Subject: RE: Planning Consultation on: LU/202/20/PD

Application No: LU/202/20/PD

Site Address: Gratwicke House 10 East Street Littlehampton BN17 6AW

Description of Works: Notification for Prior Approval under Class O for change of use of part of the building from a use falling within Class B1(a)(offices), to a use falling within

Proposed Ground floor plan (flat 5)

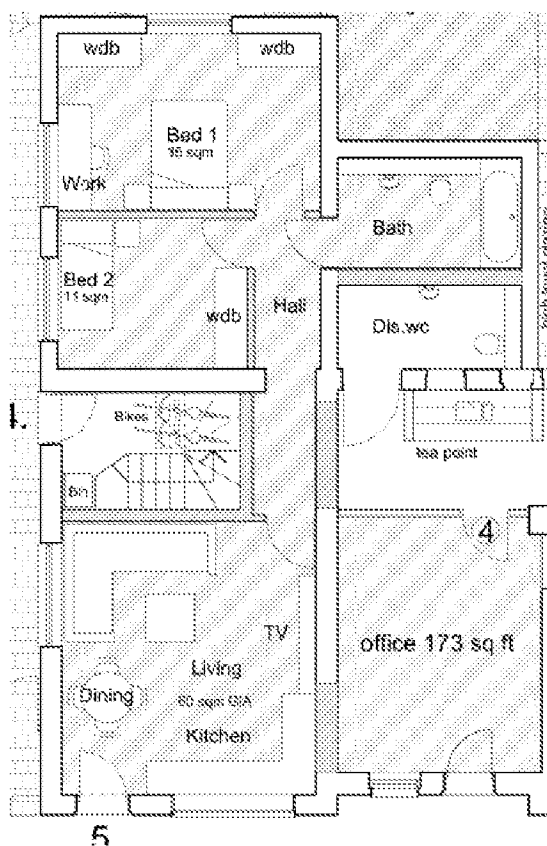
- There should be adequate fire separation between the commercial unit on the ground floor and the residential flats adjacent and above
- 30 minute fire resisting escape route to be provided to the staircase serving flat 4. This includes any under stairs cupboards within flat 5 to be fire-resisting

- As the internal escape route within flat 5 passes through the open plan lounge/kitchen and egress from the property is closer to the kitchen area, consideration should be given to installing an escape window within one of the bedrooms. An escape window should only be installed if the following criteria can be met:
